PUBLIC PLANNING SUBMISSION: AMENDED DEVELOPMENT OBJECTION

Application: State Significant Development – 138 Maroubra Road (SSD-81426710)

Perspective: Surrounding Community Members & Adjoining Residential Neighbors

SHADOW CAST BY
EXISTING BUILDING

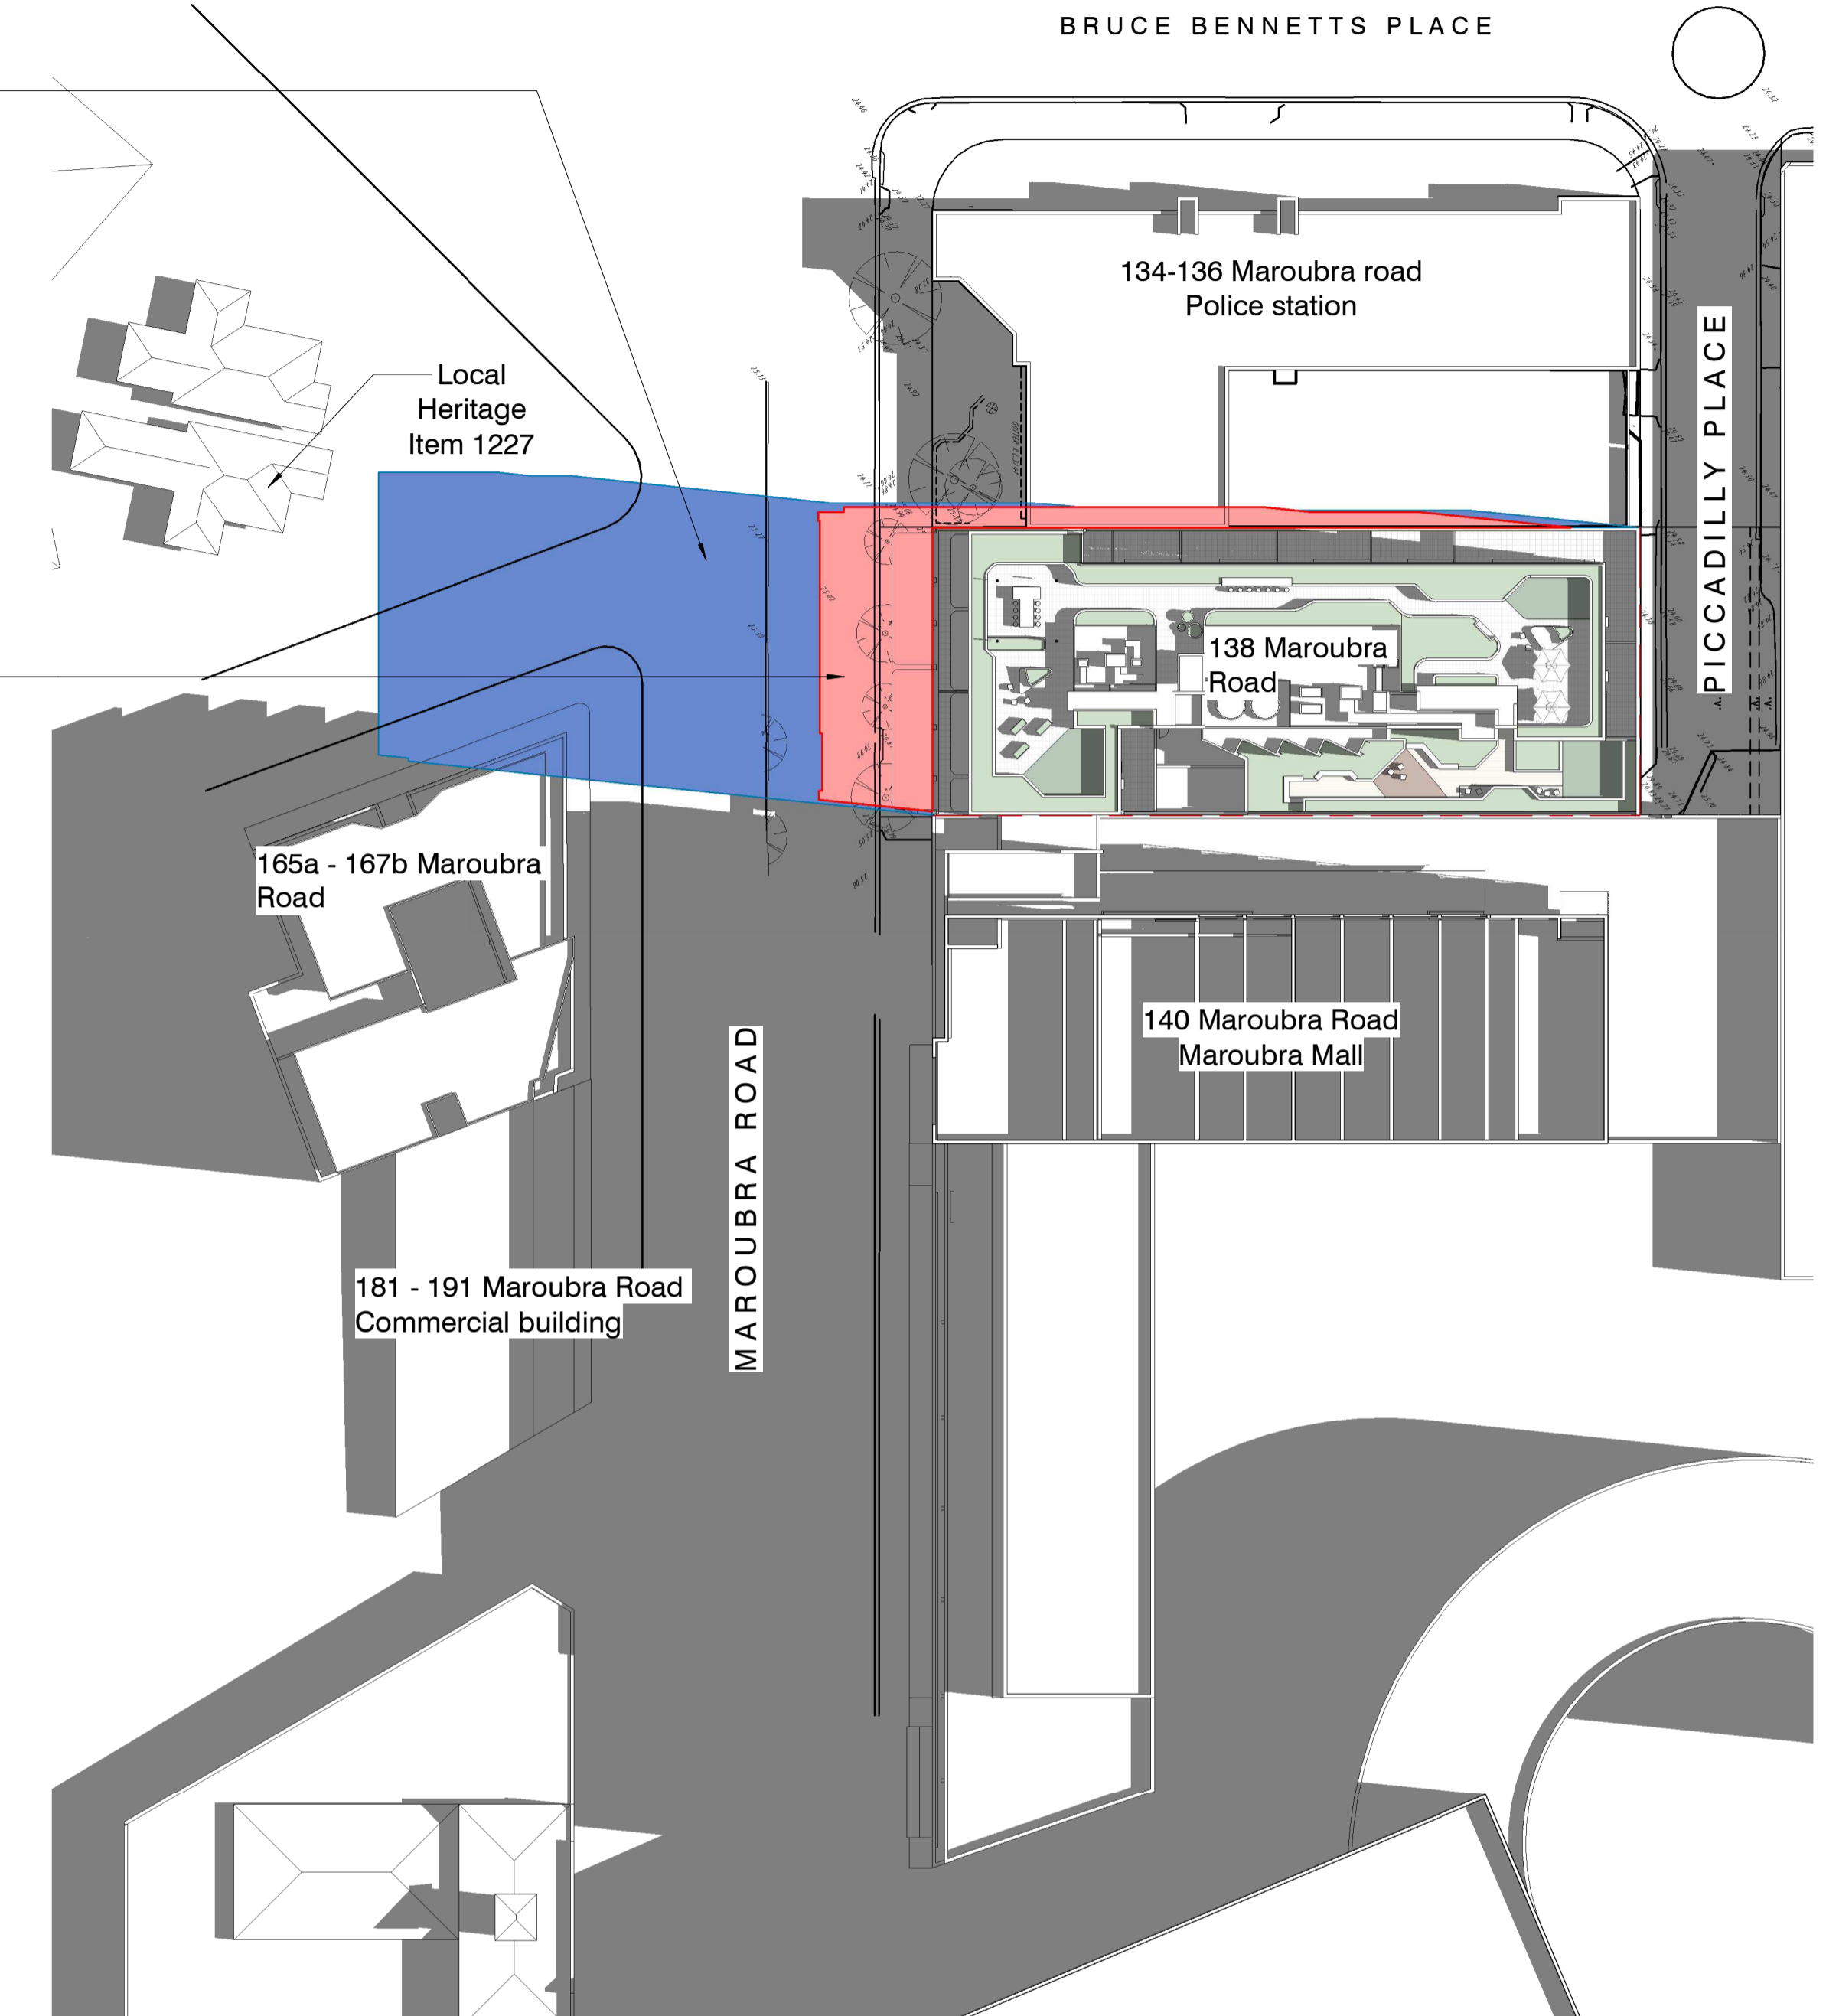
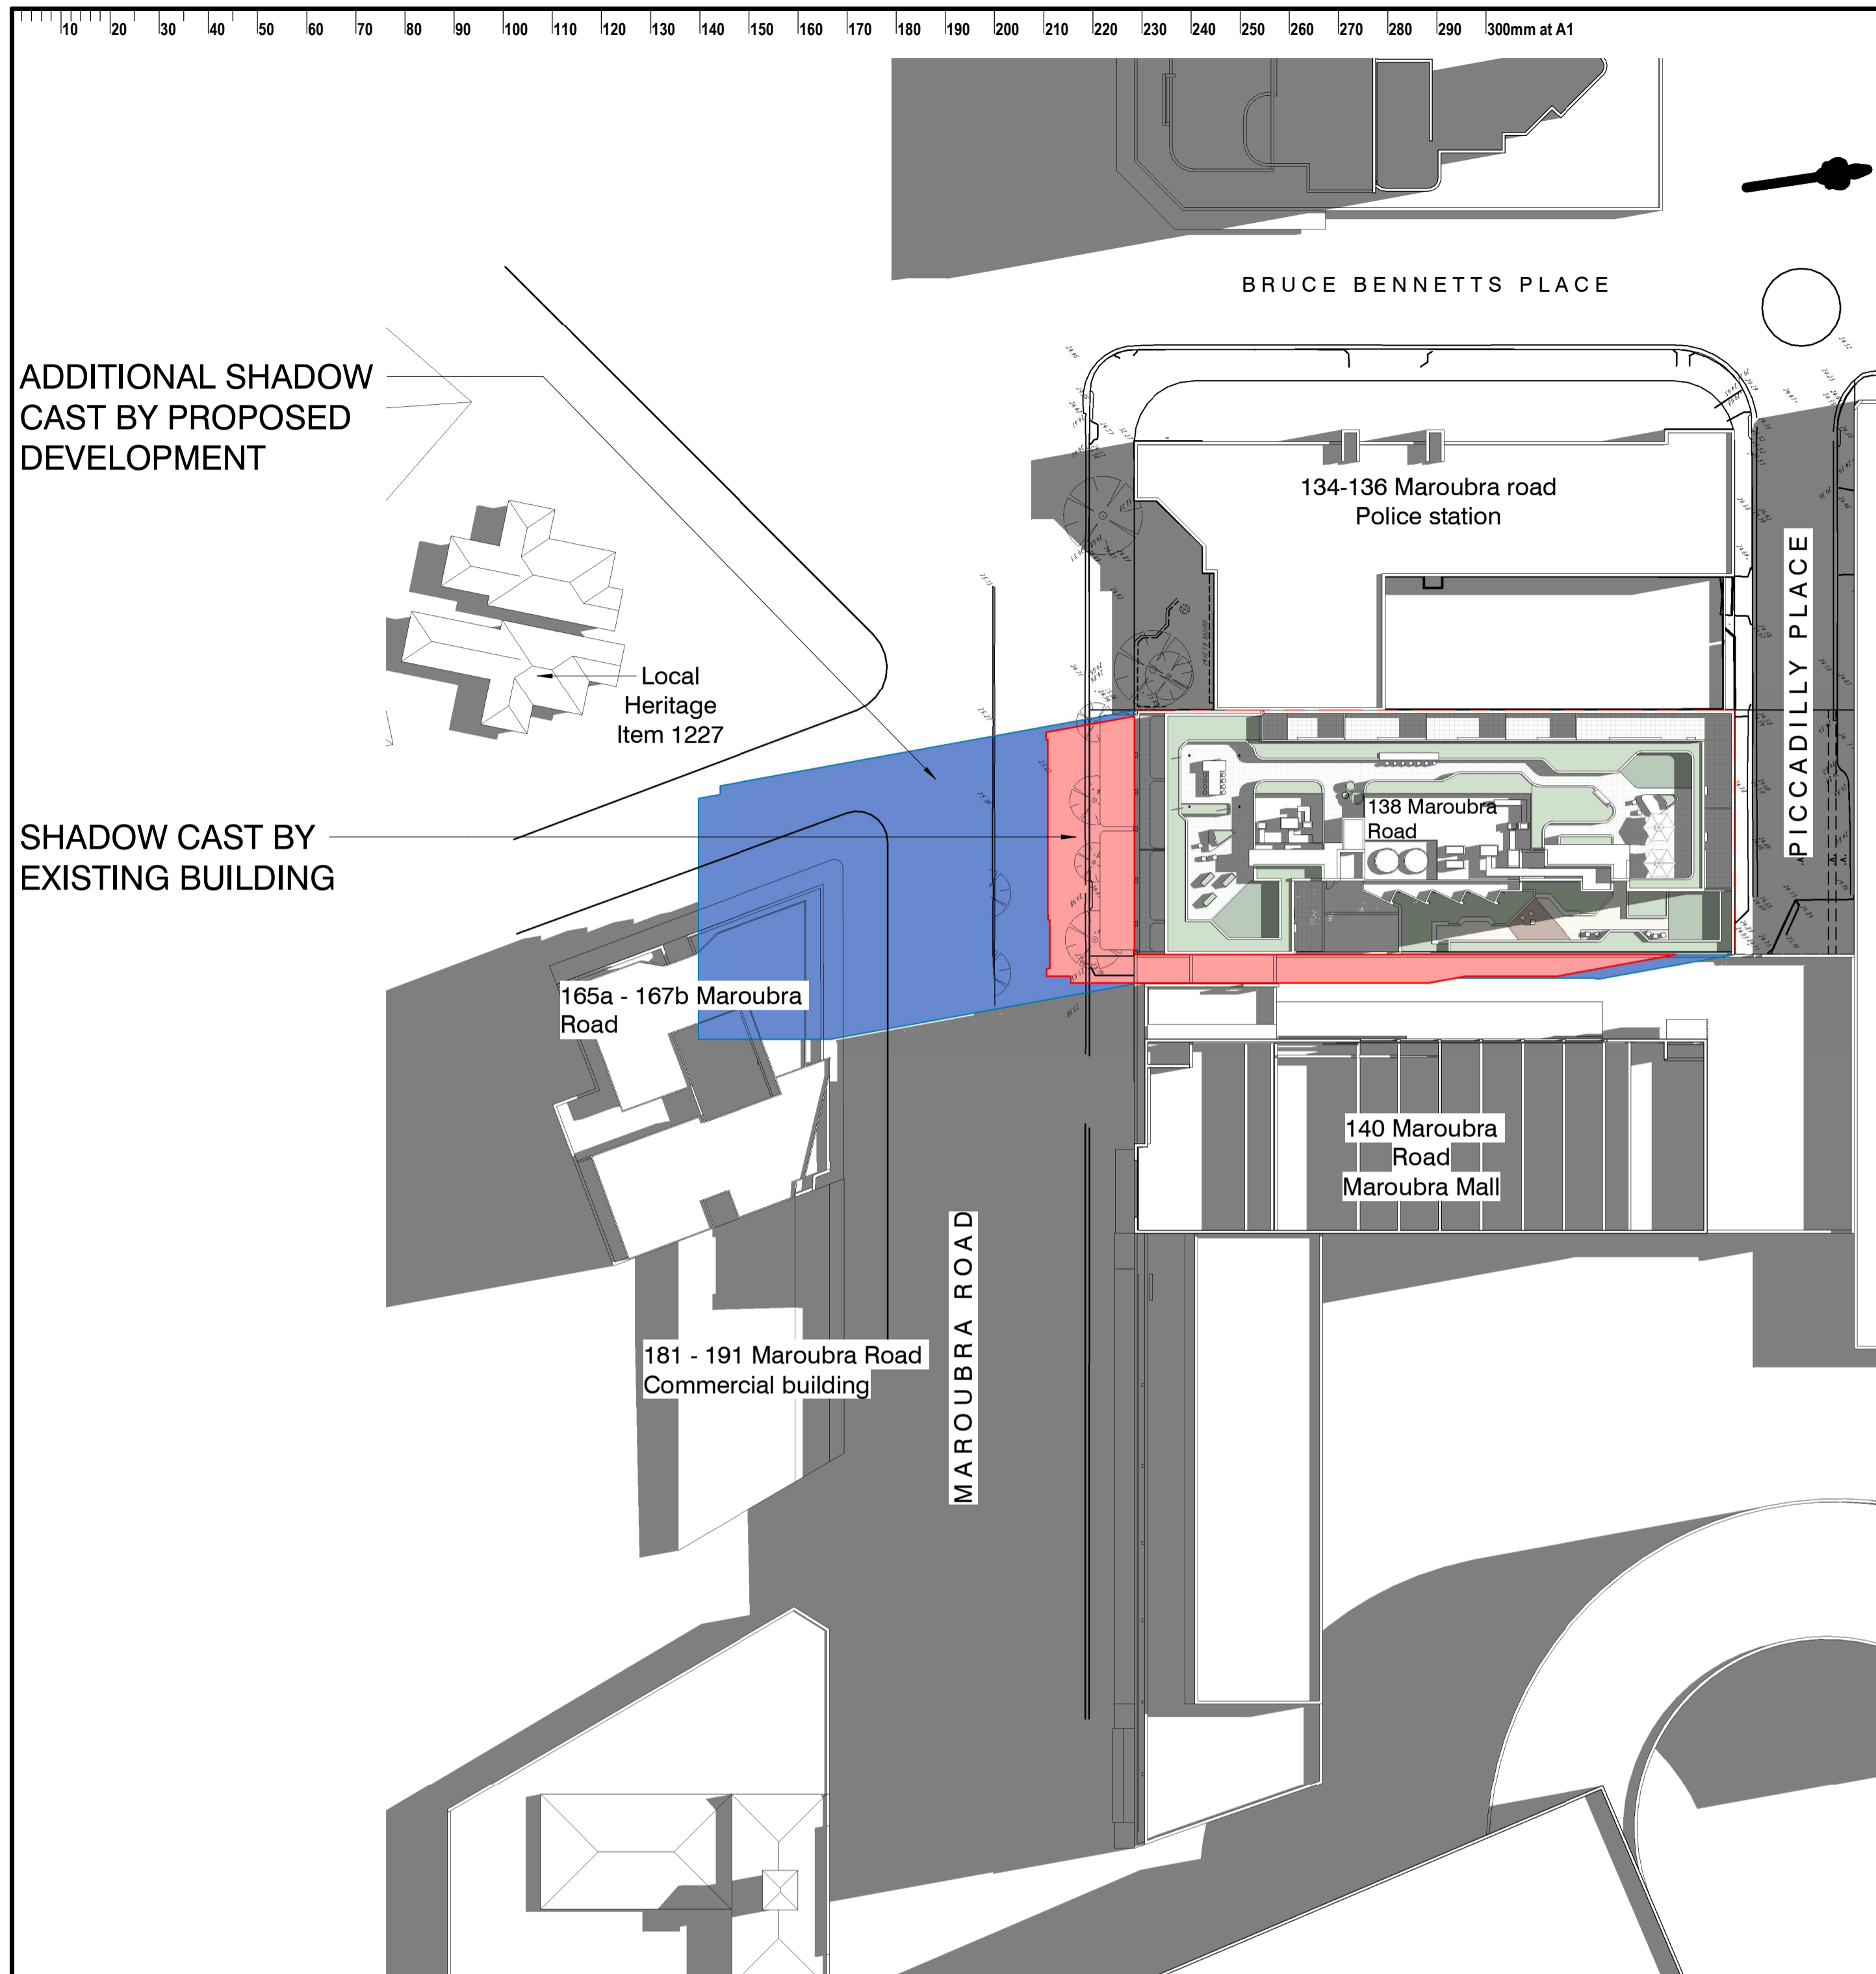
Afternoon Solar Deprivation and Extreme Microclimatic Shadowing on Adjoining Homes

The developer's updated shadow modeling relies on broad regional averages under the Apartment Design Guide (ADG), ignoring the direct microclimatic reality of neighboring properties. Constructing a deep, unarticulated 10-storey concrete envelope right to the boundary line completely blocks essential afternoon daylight.

Natural light is a crucial component of local living standards and natural apartment warmth. Depriving surrounding homes of afternoon sunlight degrades the well-being of neighboring residents. This impact is disproportionately borne by the high concentration of less-mobile senior citizens living in the adjacent building who stay indoors and depend heavily on natural sunlight for physical health and daily warmth.
